Department of Planning and Environment

Our ref: DOC22/147721

Your ref: SSD 8706

Subject: Notice of Exhibition – Night Racing at Royal Randwick Racecourse (SSD 8706)

Figure 2 Location of the Centennial Park Grey-headed Flying-fox camp

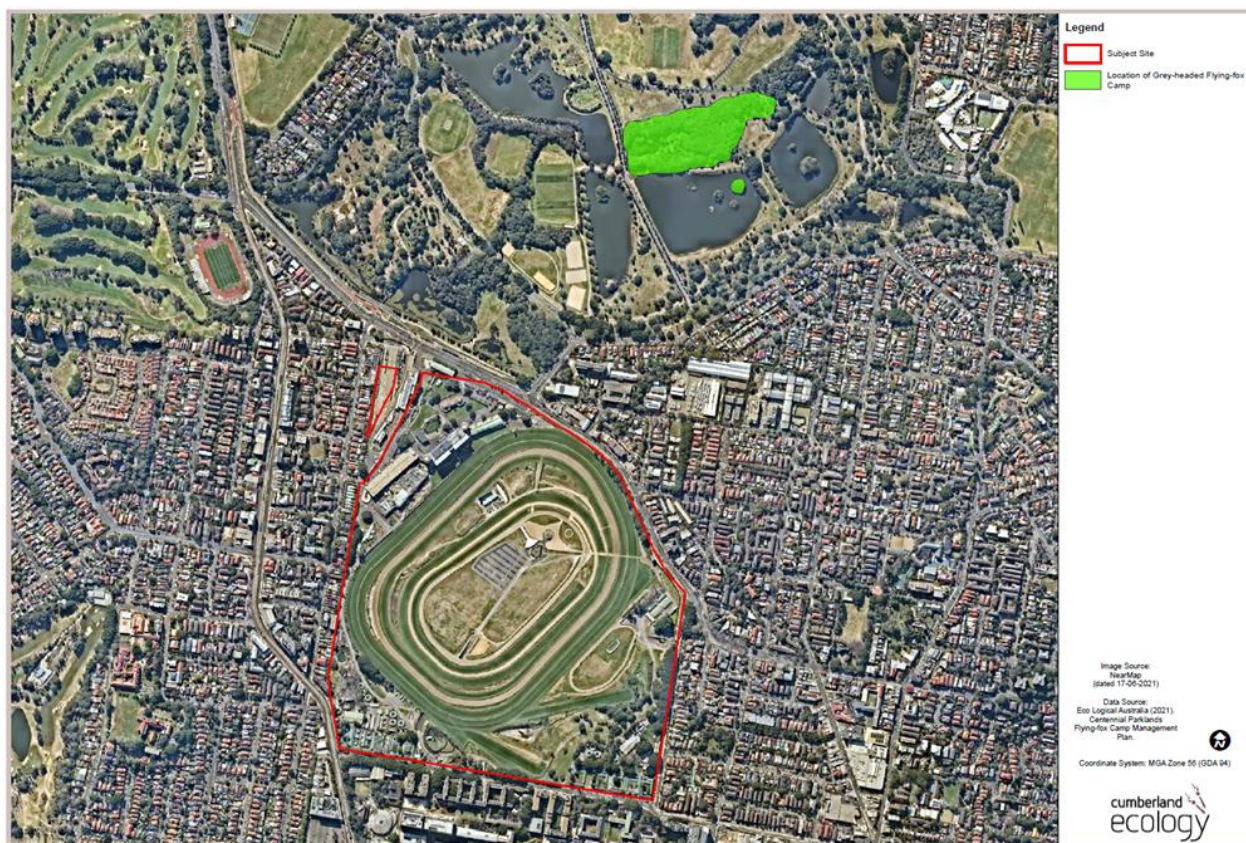
A Biodiversity Impacts Statement (BIS) has been prepared by Cumberland Ecology to address the impacts of the proposal on the nearby Grey-headed Flying-fox (*Pteropus poliocephalus*) camp at Centennial Park. EES supports the conclusions of the BIS subject to the implementation of all mitigation measures identified in the statement. The following conditions of approval are recommended to reflect the recommendations of the BIS and to manage the biodiversity impacts of the proposal.

- To address potential impacts to Grey-headed Flying-fox (*Pteropus poliocephalus*) The following mitigation measures, identified in the Biodiversity Impact Statement prepared by Cumberland Ecology (dated 30 November 2021), are to be implemented:
 - Dimming of racecourse lighting between races, to minimise the impacts of light spill through a reduction of the duration of full brightness of the lighting to approximately 8.5 hours per racing season.

- Implementation of design features such as baffles and shields to reduce the lighting levels and minimise the light spill.
- Incorporation of best practice and latest technology into the proposed design of the lighting to minimise the light spill on surrounding areas within acceptable levels.
- An ecological monitoring program is to be developed and implemented to monitor any potential adverse impacts on the Grey-headed Flying-fox colony at Centennial Park and to inform the implementation of an Adaptive Management Strategy. The Monitoring program and Adaptive Management Strategy are to be prepared in accordance with the recommendations of sections 5.2 and 5.3 of the of the Biodiversity Impact Statement prepared by Cumberland Ecology (30 November 2021) and are to be in place prior to any Night Racing events taking place.
